CITY OF ALBUQUERQUE

April 23, 2015

**Re: Anasazi Ridge Unit 3
Erosion Sediment Control Plan
Engineer's Stamp Date 4-1-15 (A11E002G)**

Based upon the information provided in your submittal received 4-1-15 the above referenced plan is not acceptable to be included in the SWPPP until the comments are addressed:

TITLE: **ANASAZI RIDGE UNIT 3
EROSION AND SEDIMENT CONTROL PLAN**

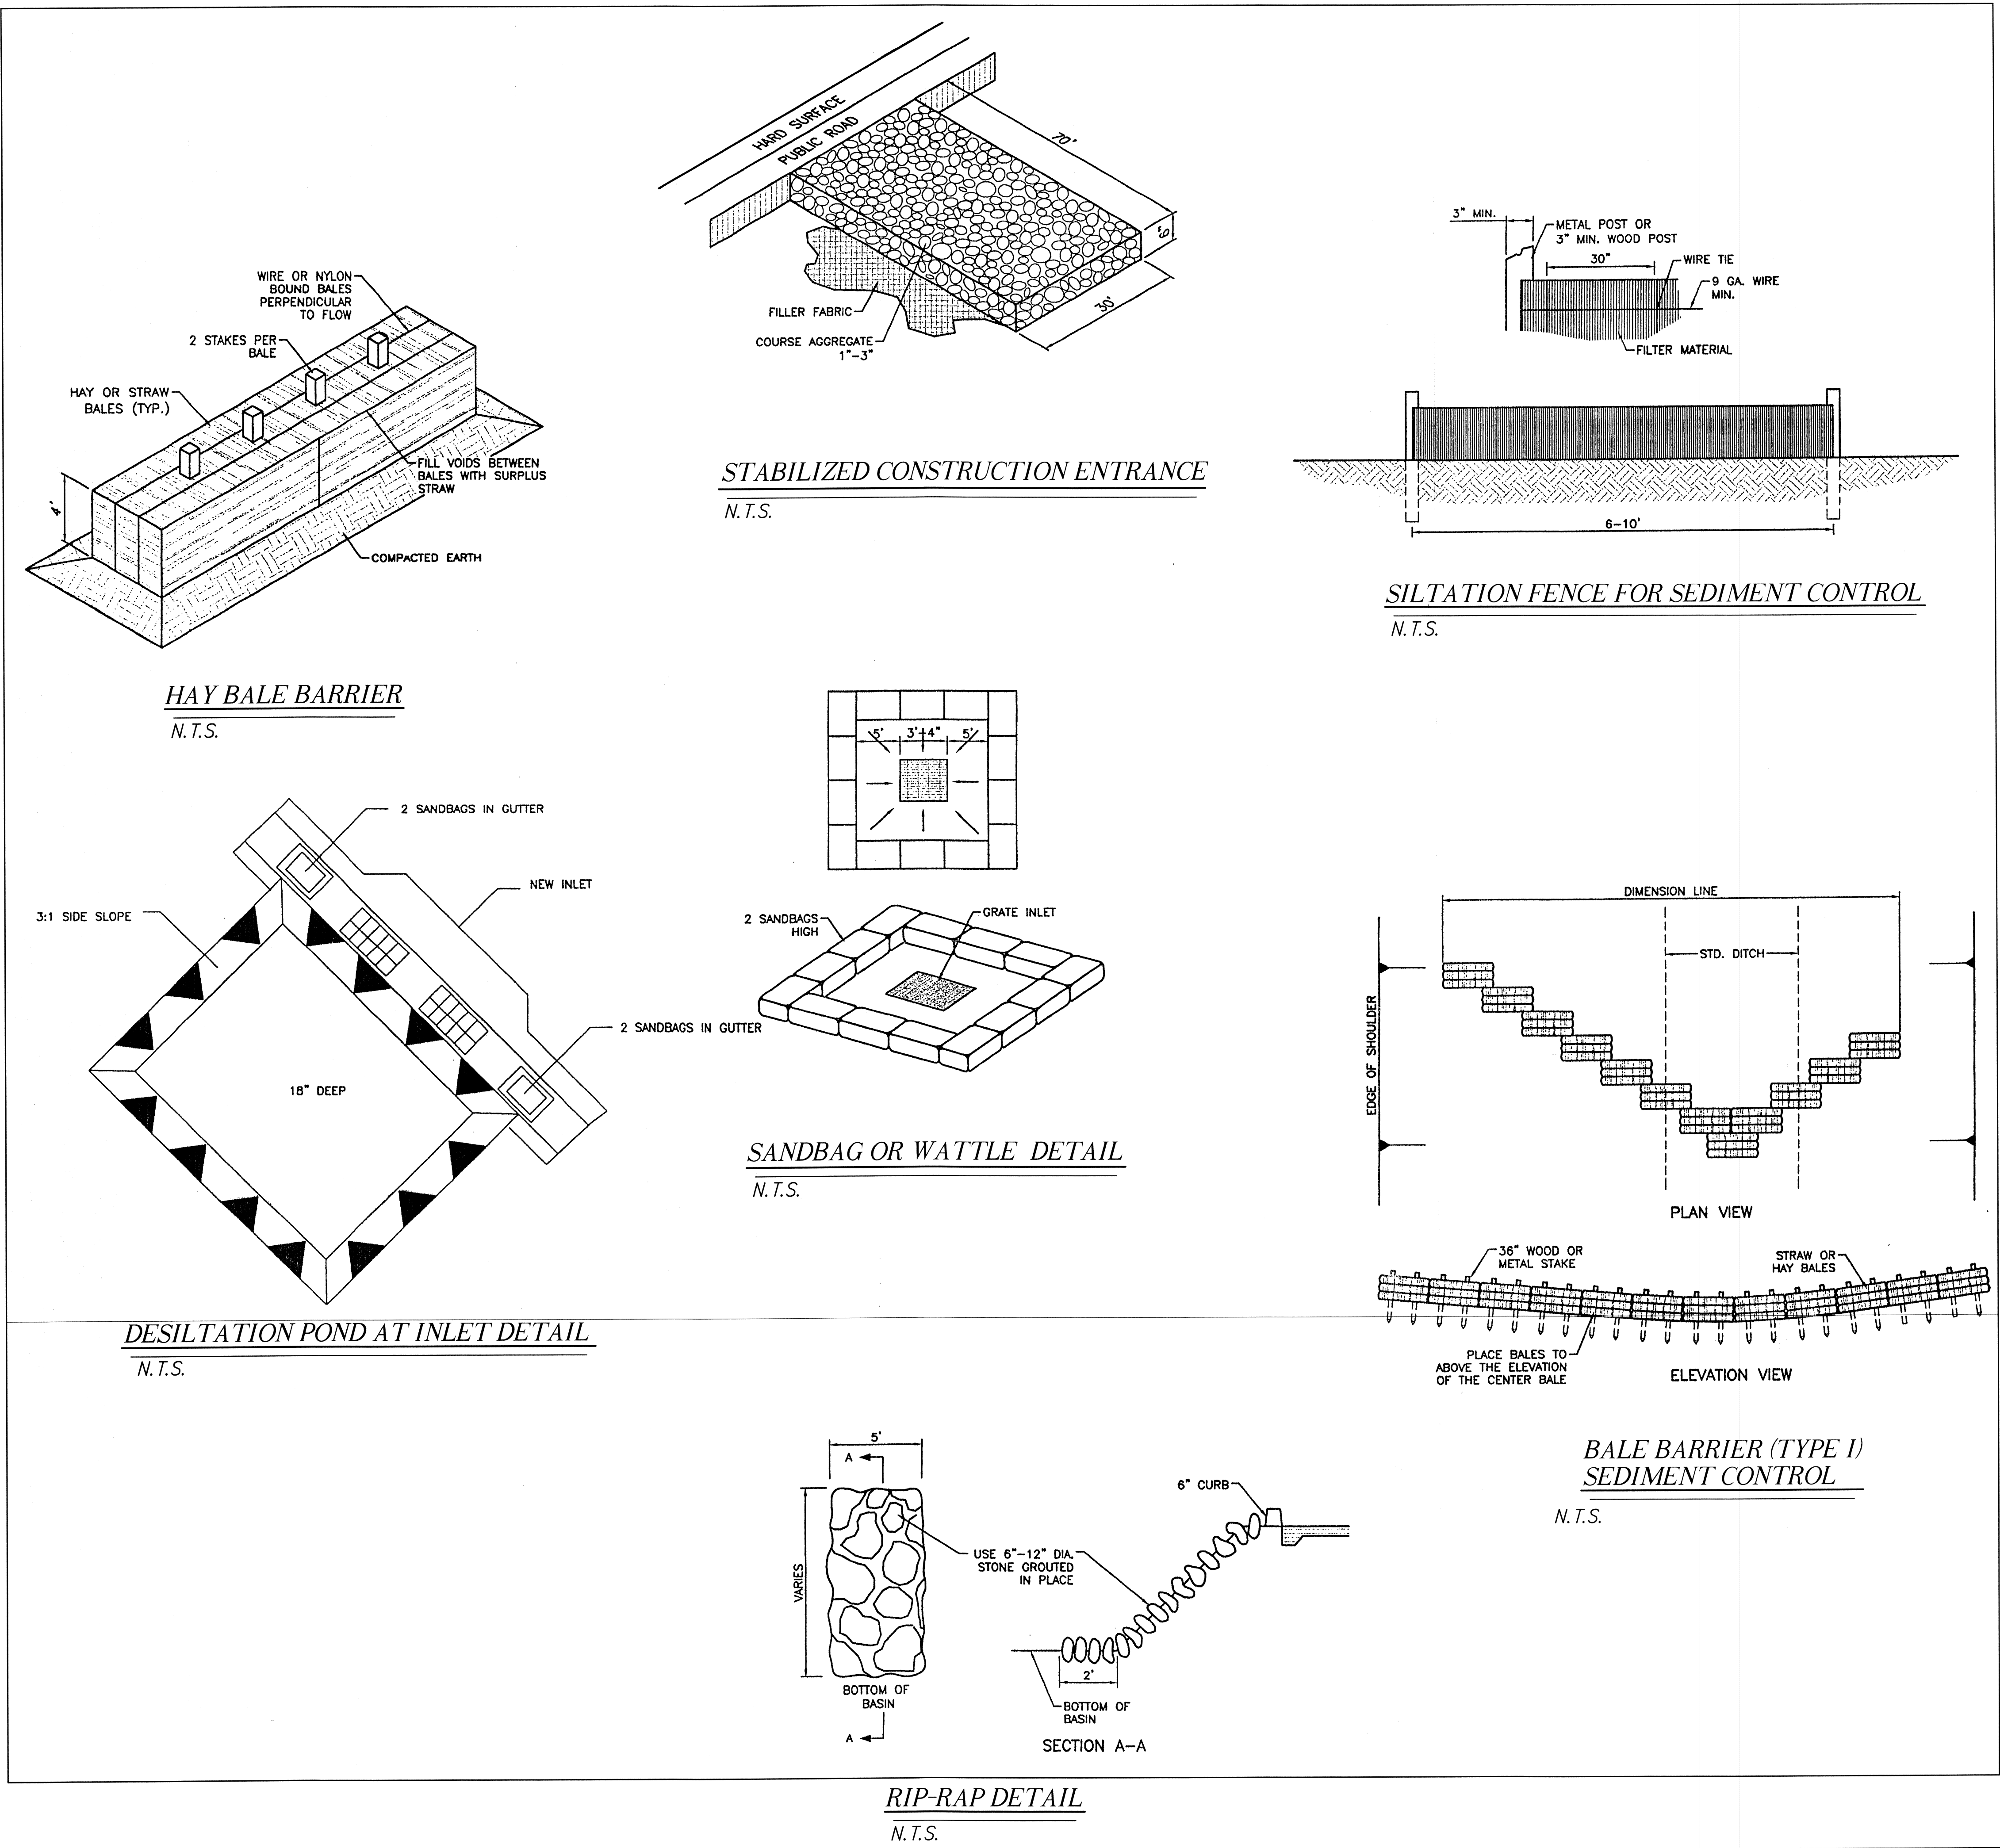
1. Erosion and sediment control BMPs are required for the construction in McMahon Blvd, Calle Vizcaya and the channel into the arroyo.
 - a. A waddle may work better for the channel due to the steepness of the grade and the amount of stormwater that may be present.
 - b. A silt fence on Kayenta near McMahon at the entrance to the channel and at the downstream end of the left turn lane in McMahon should keep dirt and debris from entering the arroyo when the construction in McMahon is occurring.
2. Straw and hay bales are not good BMP's as they degrade and enter the MS4.
3. Include a note to sweep the streets if dirt is present.
4. It seems appropriate to have a phased ESC plan. One phase for the rough grading and Construction Plan work. A second phase for after the streets are in and the pads are graded and ready for houses.
